LSC TRANSPORTATION CONSULTANTS, INC.
2504 East Pikes Peak Avenue, Suite 304
Colorado Springs, CO 80909
(719) 633-2868
FAX (719) 633-5430
E-mail: lsc@lscctrans.com
Website: <http://www.lscctrans.com>

Pinon Mesa Rock Creek
Master Traffic Impact Study
PCD File No. P209
(LSC #184380)
March 2, 2021

LSC Responses to
EPC TIS Redline
comments on
this document

Figure 13: MUTCD Warrant 2, Four-Hour Vehicular Volume (2040 Background)

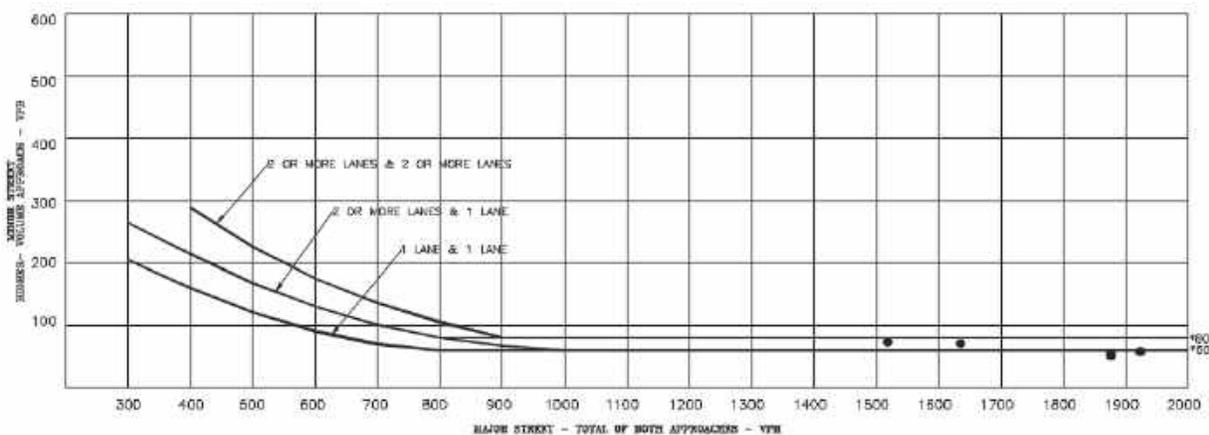
Table 6 indicates that two of the data points meet the 4-hr warrant threshold. Please revise accordingly.

Table 6 indicates that two of the data points meet the 4-hr warrant threshold. Please revise accordingly.

LSC Response: This text has been revised in the updated TIS report to match Table 6 and reflect the correct number of data points (two) meeting the 4-hour warrant threshold.
